From: Richard.Temple@arun.gov.uk
To: [REDACTED]
Subject: FP/36/15/HH 36 Whitelands, Felpham
Date: Tue, 26 May 2015 15:50:40 +0000

I am the officer dealing with the above application.

MICHAEL CLAYTON 36 WHITELANDS FELPHAM. P022836

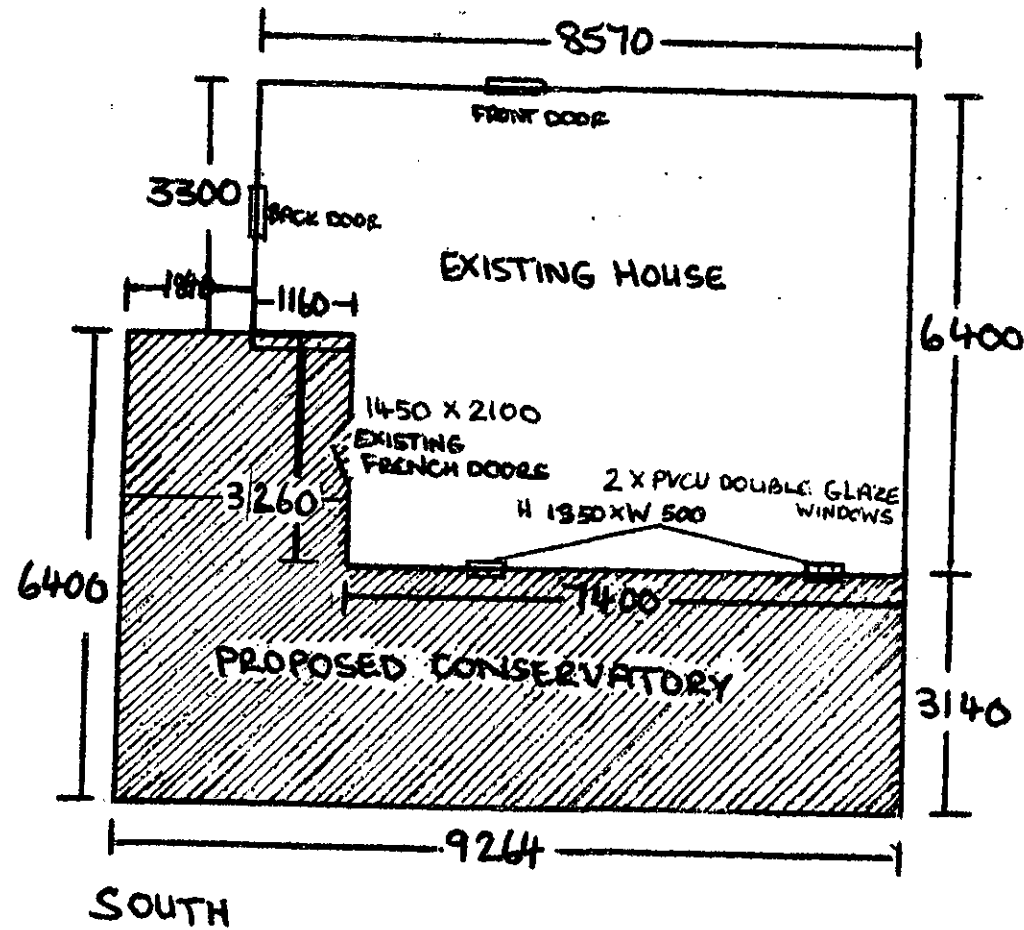
I was just writing the application up for approval and noticed that the hand drawn plan floorplan of the house and extension have east and west marked the wrong way around.

Would you be able to amend the plan and scan it to send as an email to me?

Thank you for pointing out my mistake and please find the corrected attachment as requested.
